From: Grant Harlow <GHarlow@martens.com.au>
Sent: Monday, 30 August 2021 9:00 PM
To: Christopher Fraser
Cc: Rob Brook [Newcastle Legal]; Paul Mitchell; Daniel Martens; carlod
Subject: RE: DA S29/3/97-Mod-1 - Eastern Creek Karts - Request for Information

Hi Chris, Please refer to tabulated response below to DPIE RFI date 19.08.2021 and referenced items in the following drobox link:

- Turfing/lawn substitutes
- Microlaena stipoides (Weeping grass) - refer detail
- Stabilized recycled road base - refer detail
- Existing trees & landscape condition to remain
- Trees proposed to be removed and replaced with new landscaping
- Existing trees proposed to be retained and protected

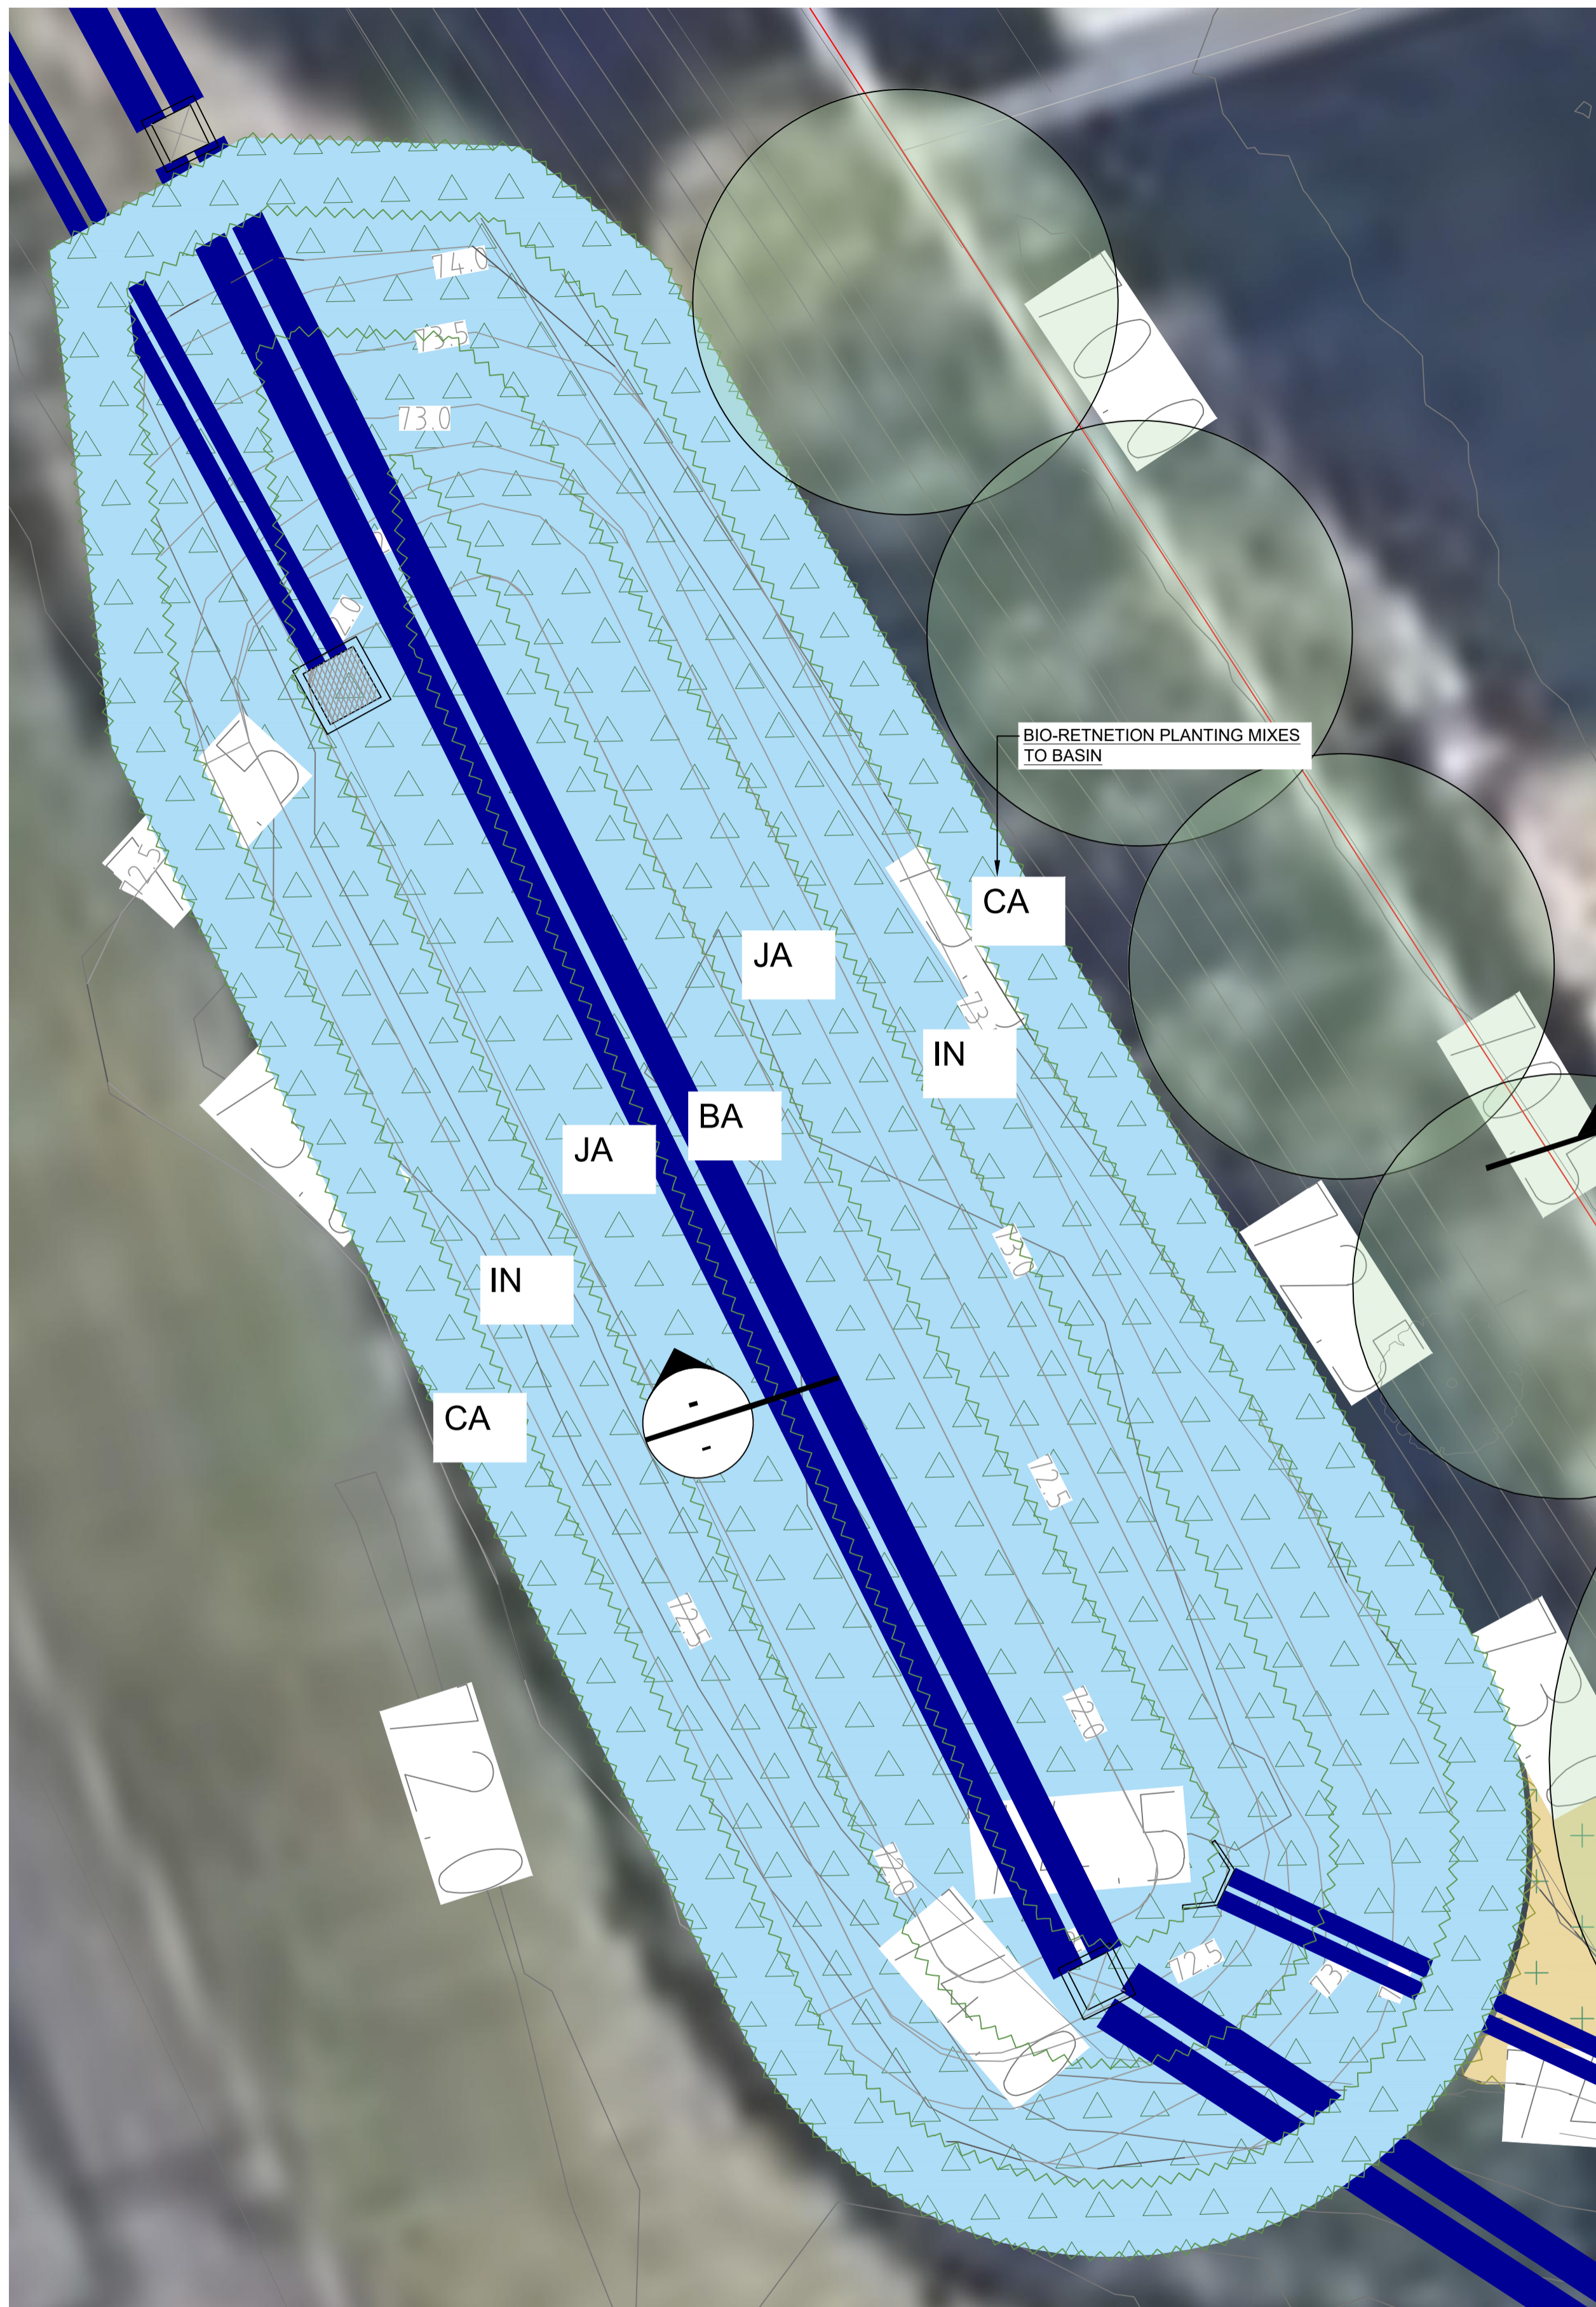
3. Proposed Landscaping on steep batters Landscaping Plan LPS4.55 - 22/31 by Conzept Landscape Architects is noted. Concern is raised for the planting of tall canopy species Angophora costata and Corymbia maculata in areas : • near proposed pipe drainage, or • on steep batters and retaining wall systems that may not have anticipated all design load surcharges. It is requested the Engineer and Landscape Architect confirm suitable locations for the canopy species where mature tree growth would not impact the service life of drainage pipes, and the Engineer provide assurance for the structural capacity and safety of the proposed batter and retaining wall systems given the canopy trees' anticipated surcharge loadings. Should any planting be reconsidered due to drainage or structural capacity concerns, please provide a revised planting design prepared by the Landscape Architect and supported by the Engineer in writing, to address matters of visual impact raised by the Department in the RFI letter of 13 May 2021 Appendix 1 Section 6.	The landscape architect has amended to the Landscaping Plan to remove the tall canopy species trees and replace with much smaller, lighter alternatives.
